AMA Designer's Response

Proposed Residential Development – Westgate, Cleckheaton

21st March 2022

Planning Ref:	N/A
Drawing Number:	18-CL2-SEGB-WE-01
Revision:	P

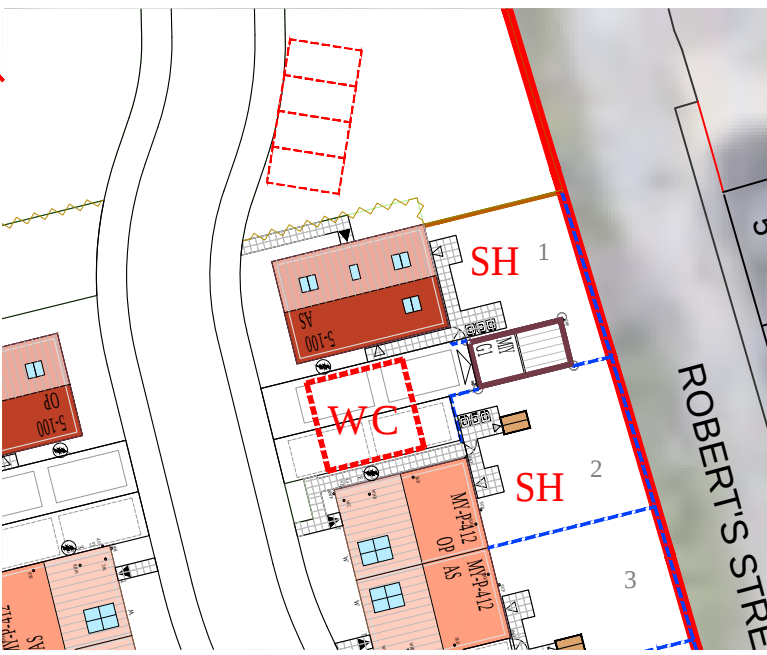
A lack of suitable pedestrian footways, poor carriageway condition and pedestrian barrier will increase the risk of pedestrian/vehicle and cycle vehicle collisions.

The drawings provided show that a new pedestrian link will be provided between the development and Quarry Road. Currently there is only a short section of heavily overgrown footway available and is shown in the photograph below.

In addition, a new pedestrian link will also be provided from the site onto Brick Street. No footways are proposed and therefore pedestrians will be required to walk across an area of uneven ground and within the carriageway.

It will be necessary to provide footways for pedestrians exiting the site onto Brick Street. If pedestrians are expected to walk in the road, then the developer needs to consider remedial action that will make the existing uneven carriageway into a safe environment for pedestrians to use.

Summary: *Footways and priority junctions are proposed throughout the development site. Details of the internal layout does not show any internal uncontrolled crossings within the development site and specifically at the proposed priority junctions and the NMU route mentioned in problem 8 below.*

Summary: *The drawings provided show that a new pedestrian/cycle link will be provided between plots 74/113 and 96/97.*

The Audit Team were concerned that cyclists and young children could run or ride straight onto the internal road layout.

Provide staggered barrier at either end of the internal NMU route.

Pedestrian routes connections to Brick Street and Quarry Road will be added at detailed design.

The specific details regarding the appropriate location and make-up of the dropped kerb pedestrian crossings will be included within the Section 38 design package.

A suitable cycle/pedestrian barrier in the form of a 'chicane' staggered barrier will be included as part of the detailed design stage for both the NMU links onto Quarry Road and Iron Street.
